Recommendation Report for Planning Permission

REF NO: BR/190/17/PL

LOCATION: 76 London Road
Bognor Regis

PROPOSAL: Two & part three storey rear extension for an additional 3 No. dwellings.

02

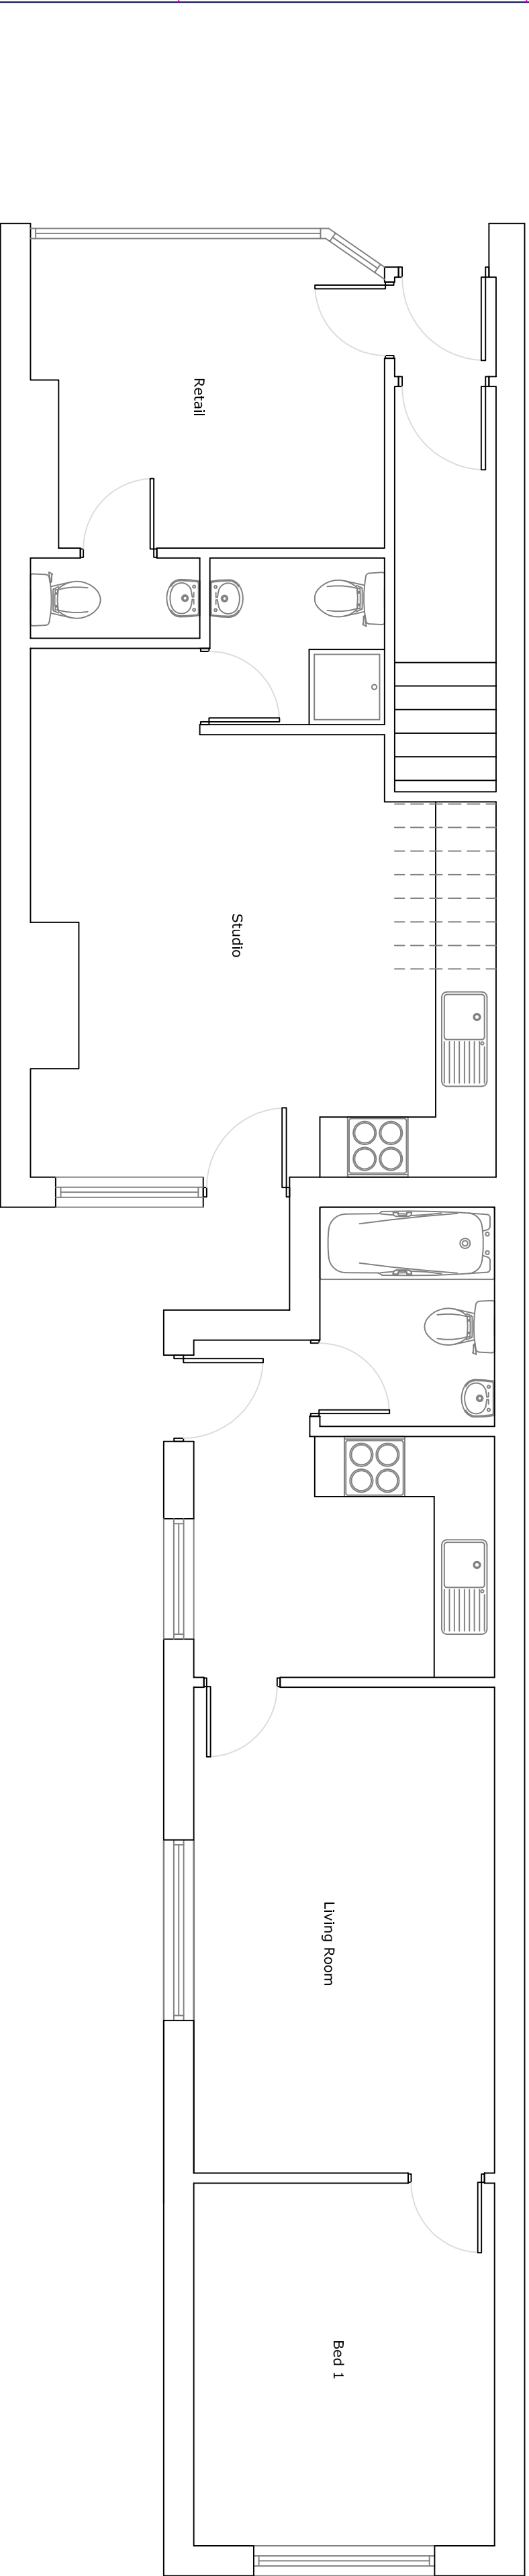
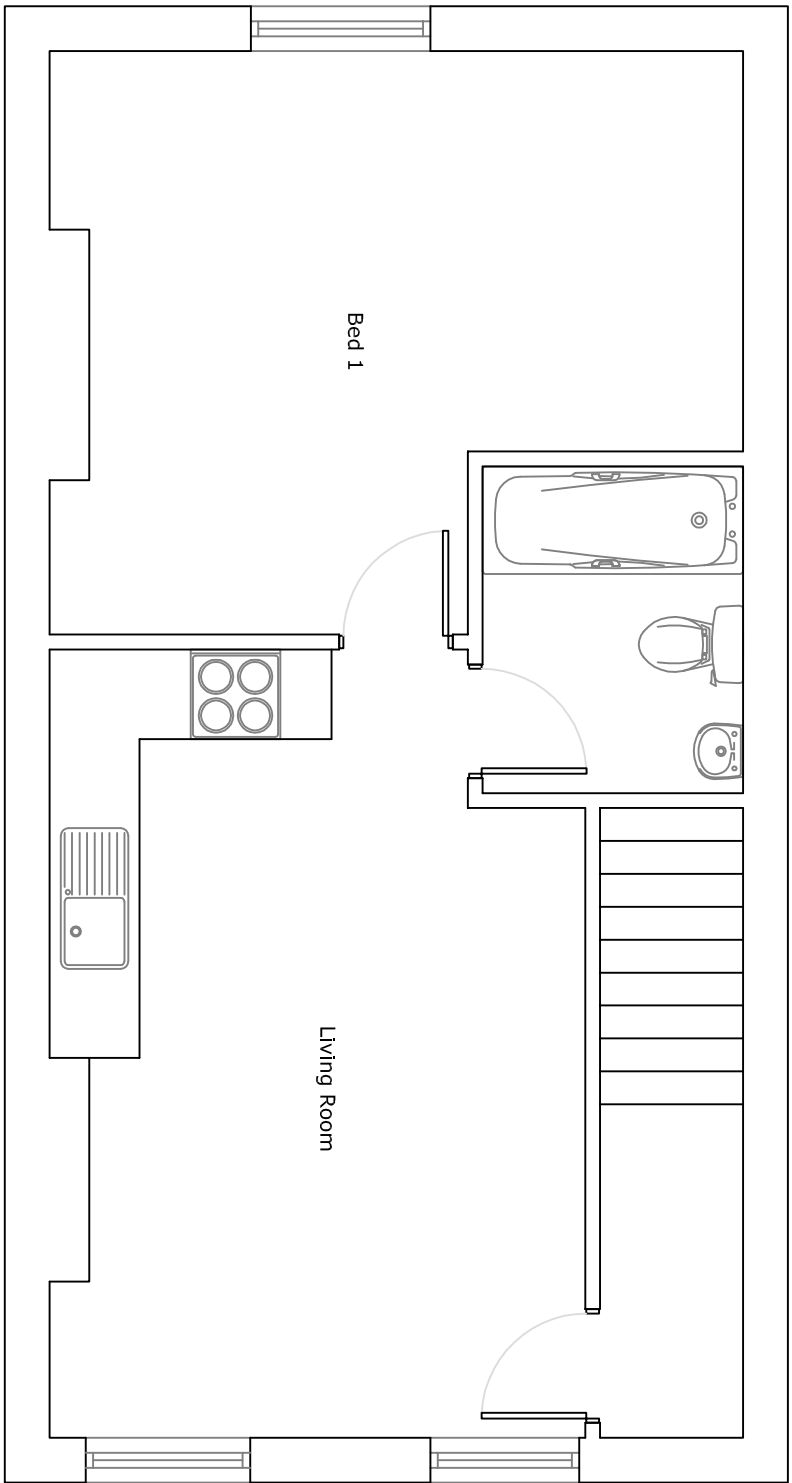
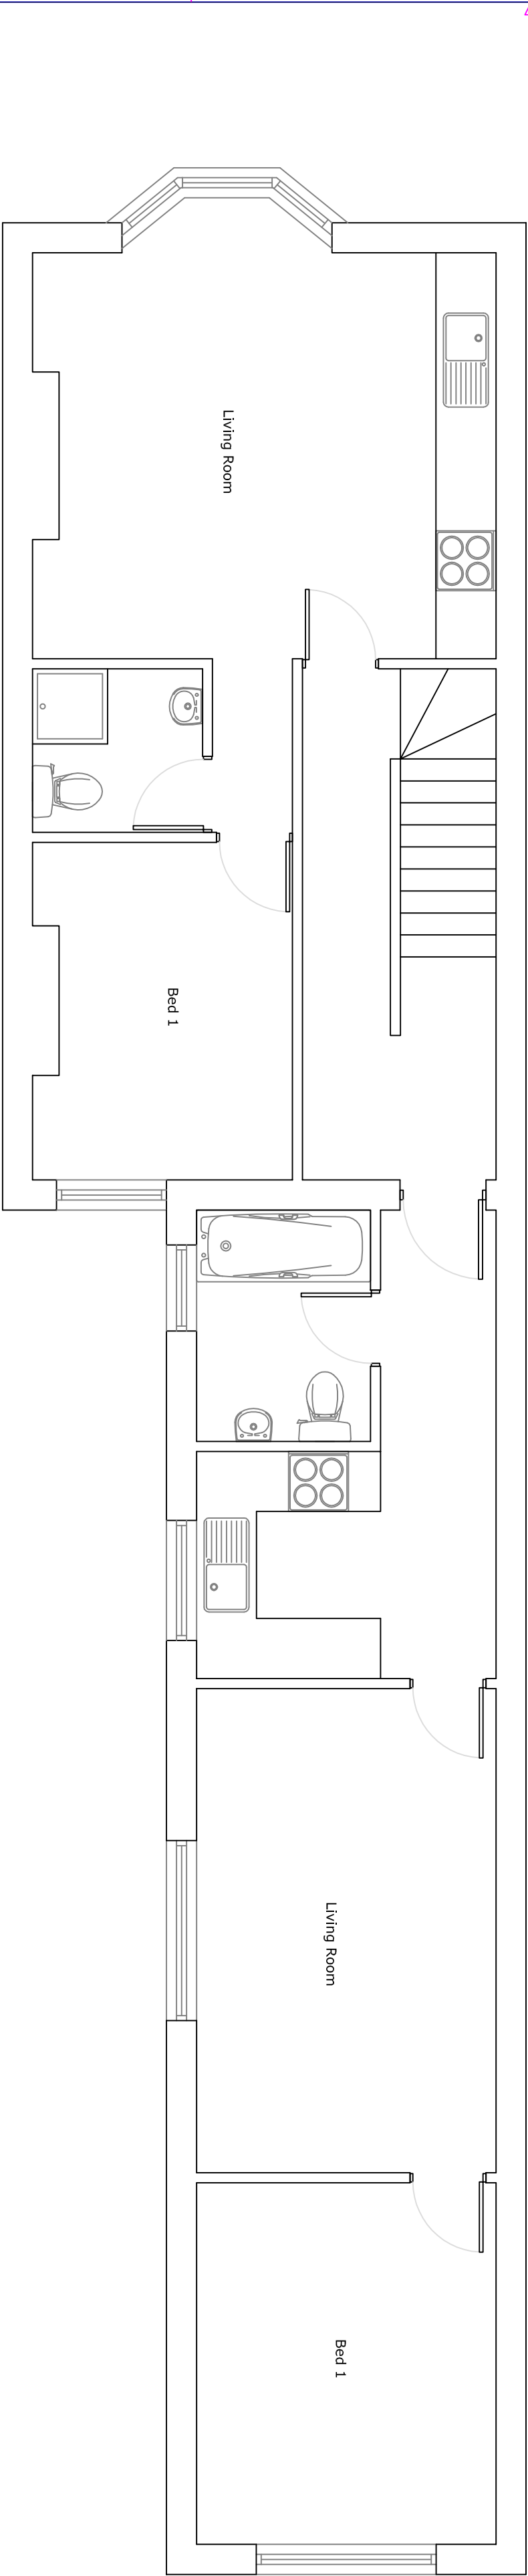
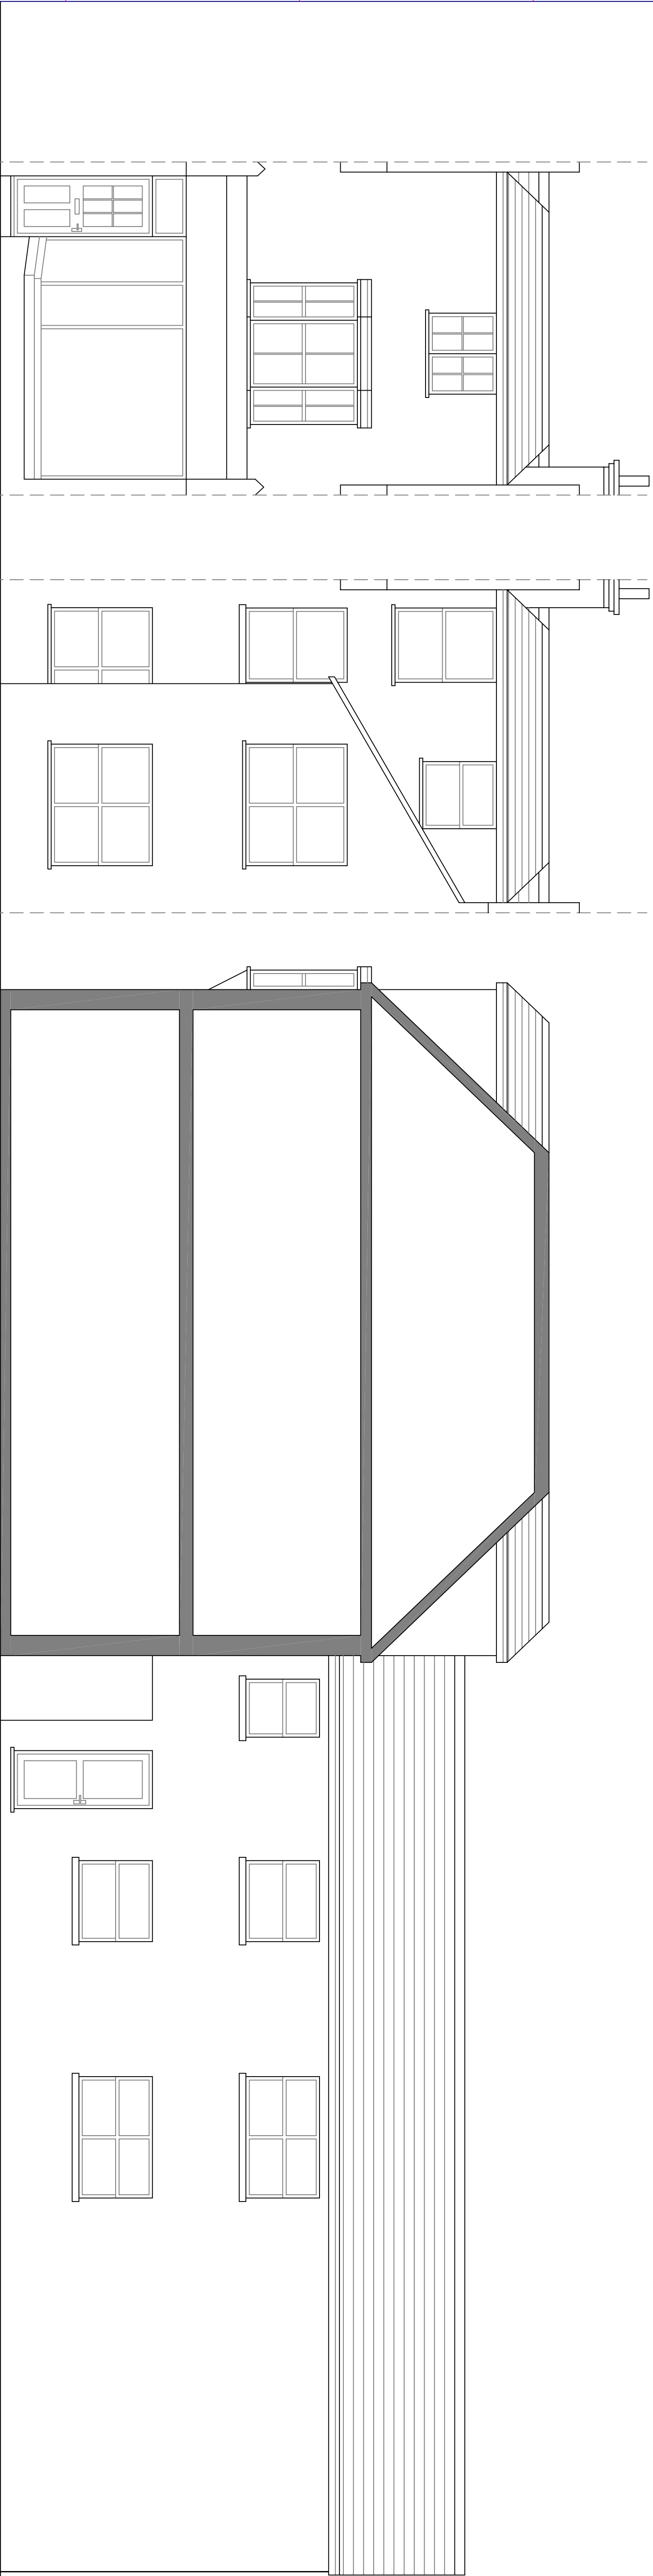
The existing ground floor class A5 takeaway will be reduced in size from 18.3m² to 10.2m² and will lose its access to the rear yard. However, it will also have a separate 6m² space comprising toilet (1/4) and storage (3/4). The rear yard will provide cycle and bin storage for the flats.

ADC ECONOMIC DEVELOPMENT: "Economic Development would object to this application. The reduction in retail space would likely impact the viability of this unit as a retail space. There is no storage space or service area, meaning that all goods storage/food preparation etc would have to be in the same space as the sales area. Whilst many companies now operate with less stock than previously some storage space would be required."

A condition is proposed to ensure that the ground floor bathroom window is obscure glazed in the interests of public decency and occupier privacy.

- A room where the only escape route is through another room is termed an "inner room" and poses a risk to its occupiers if a fire starts unnoticed in the outer room. The escape routes from all flats is via the kitchen, this can be overcome by ensuring that the window in the bedroom is an escape window and adequate fire protection within the flat. However, an escape window is not acceptable above 4.5m above ground level therefore the layout on the second floor would need to be reconsidered.

Comments noted. The plans have been amended to provide the retail unit with a small separate storage room.

The comments of Economic Development and of the local resident are noted and these led to the application being amended to provide the retail unit with a storage room. This will make it a more viable business space.

- 6 The ground floor bathroom window (flat 1) shall at all times be glazed with obscured glass.

Itemref	Quantity	Title/Name, designation, material, dimension etc			Article No./Reference
Designed by	Checked by	Approved by - date	Filename	Date	Scale
76 London Road			Proposed Conversion	May 2017	1:100 / 1:50
			04		Sheet

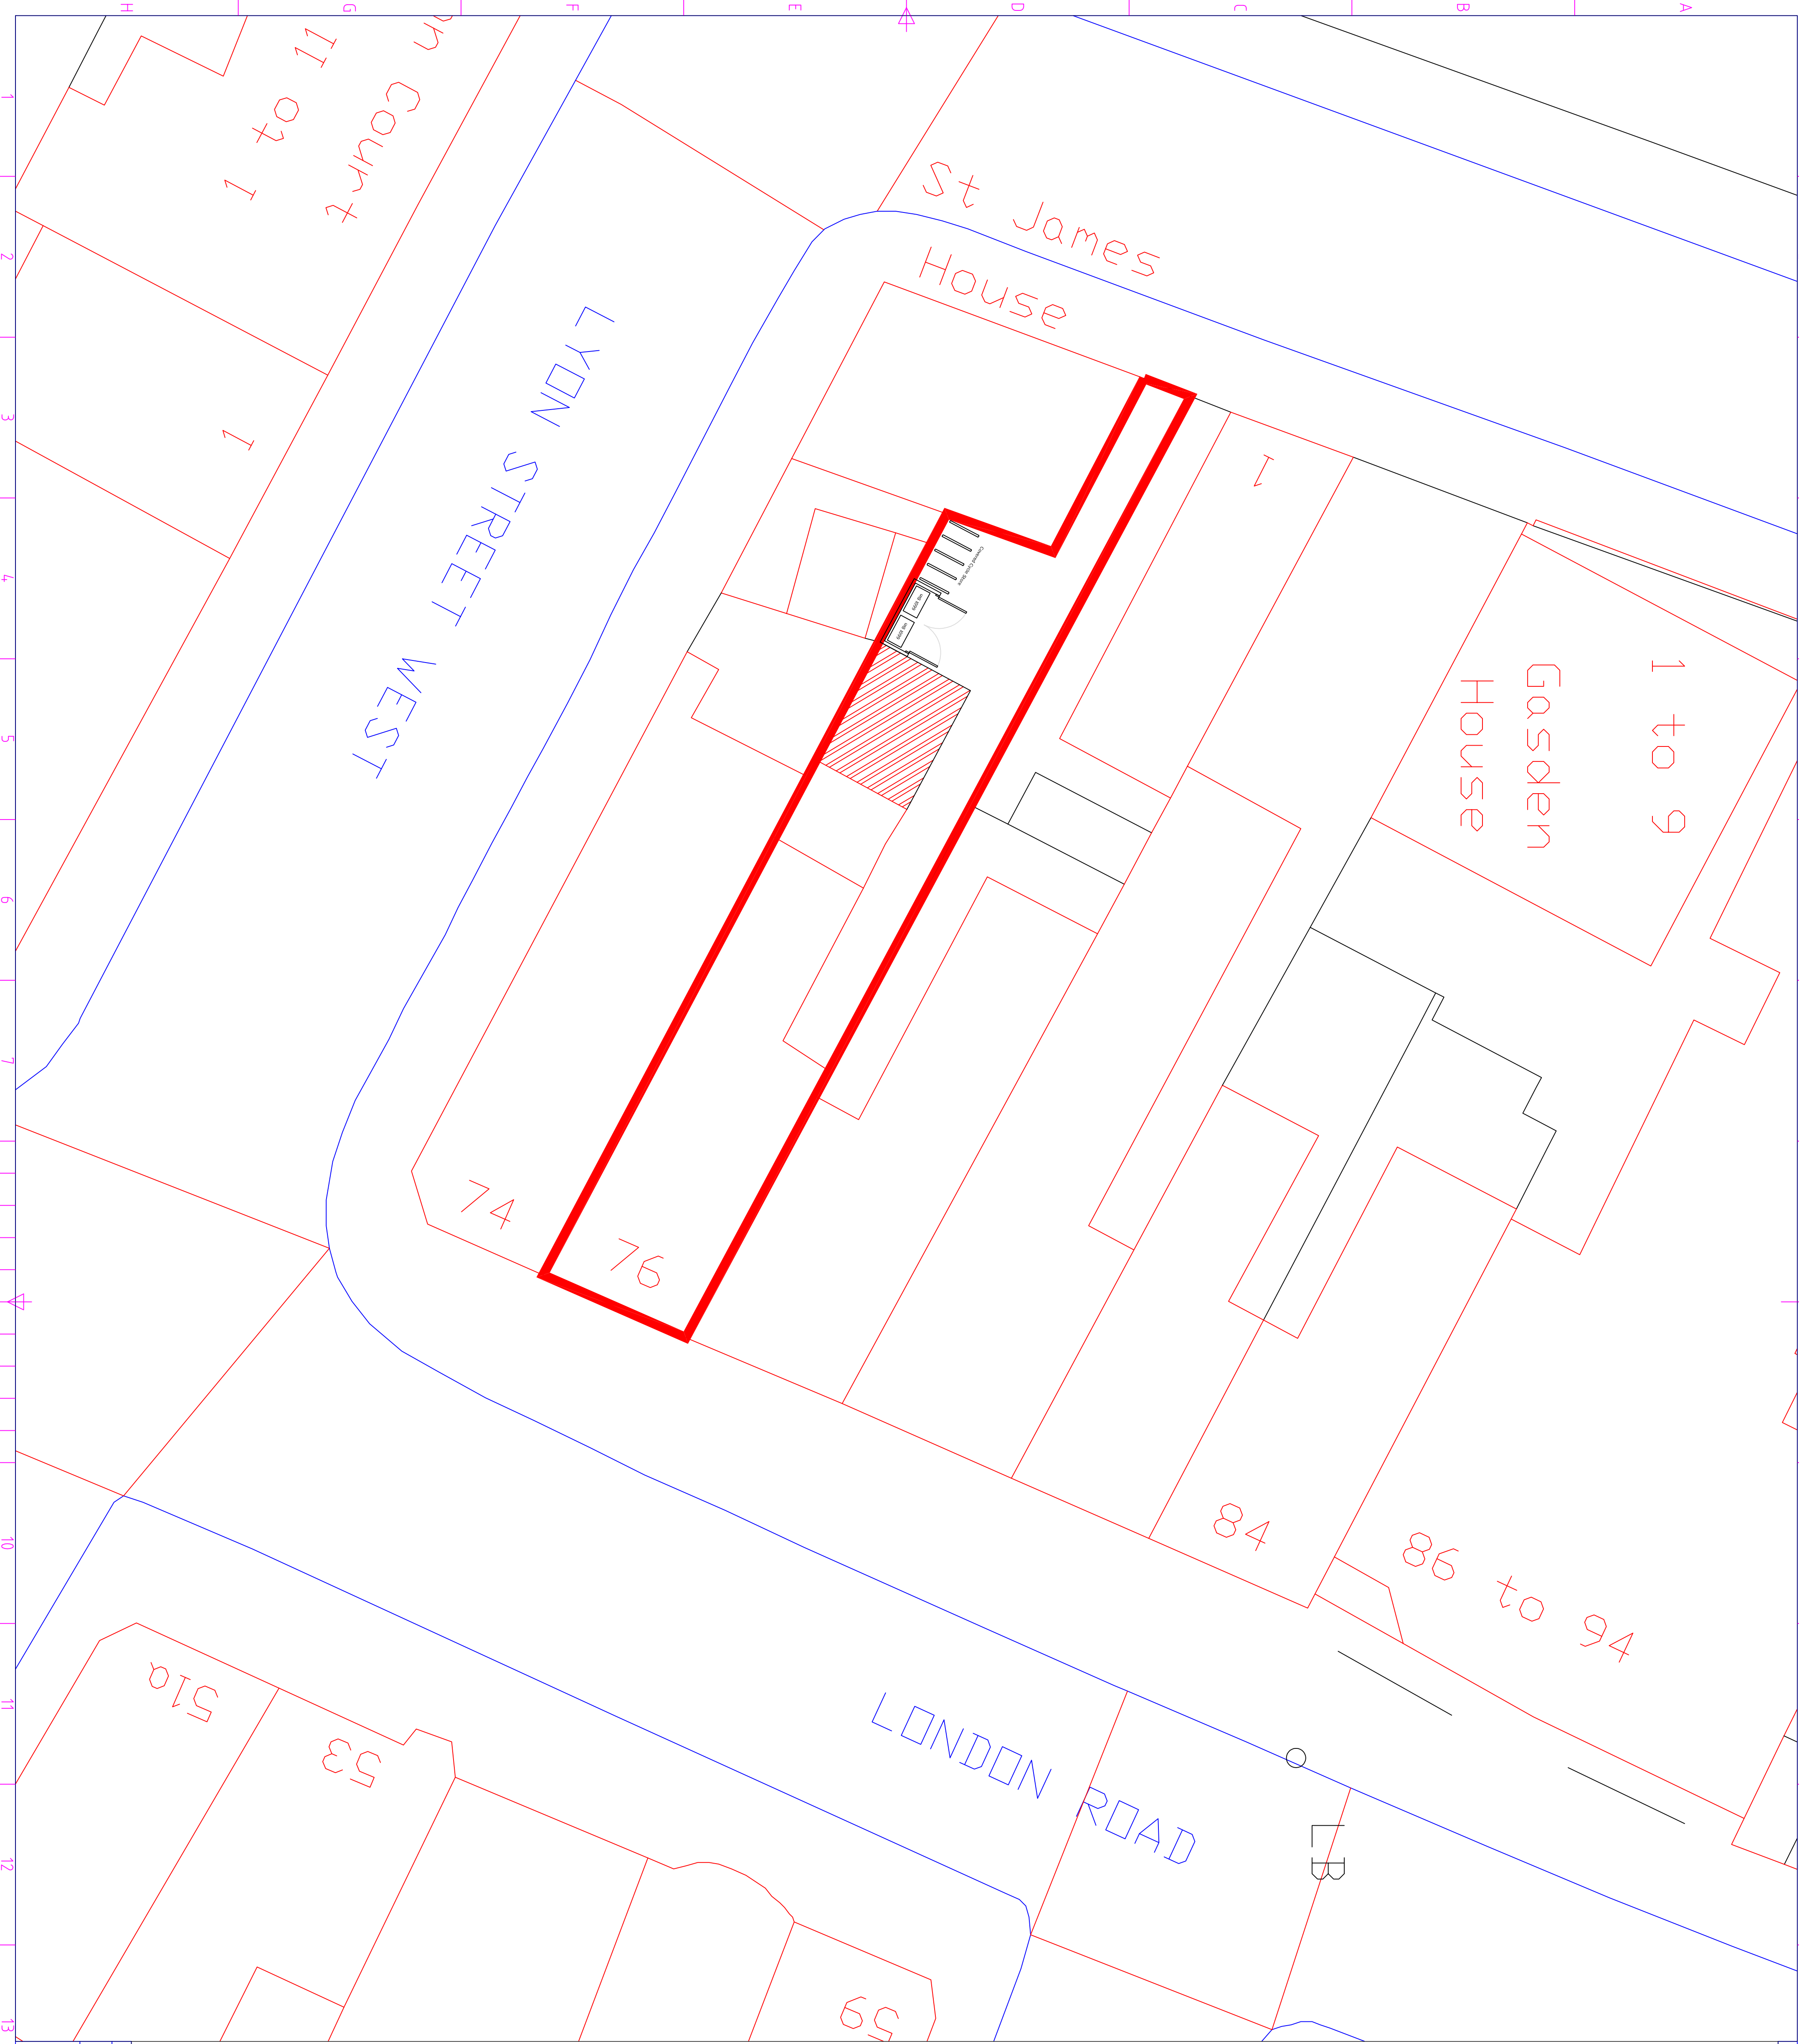
Furthermore, the location is suited well to utilisation of sustainable modes of transport such as by foot, bicycle, bus or train. A range of amenities and services are also within walking distance in Bognor town centre. Secure and covered bicycle storage should be provided as per the supplied plans, this can be maintained and secured in perpetuity via condition.

- 4 The covered cycle store as shown on Dwg. 04 "Proposed Block Plan" shall be implemented prior to the occupation of any of the flats and shall then be permanently retained and maintained in good working condition.

- 5 The bin store building as shown on Dwg. 04 "Proposed Block Plan" shall be implemented prior to the occupation of any of the flats and shall then be permanently retained and maintained in good working condition.
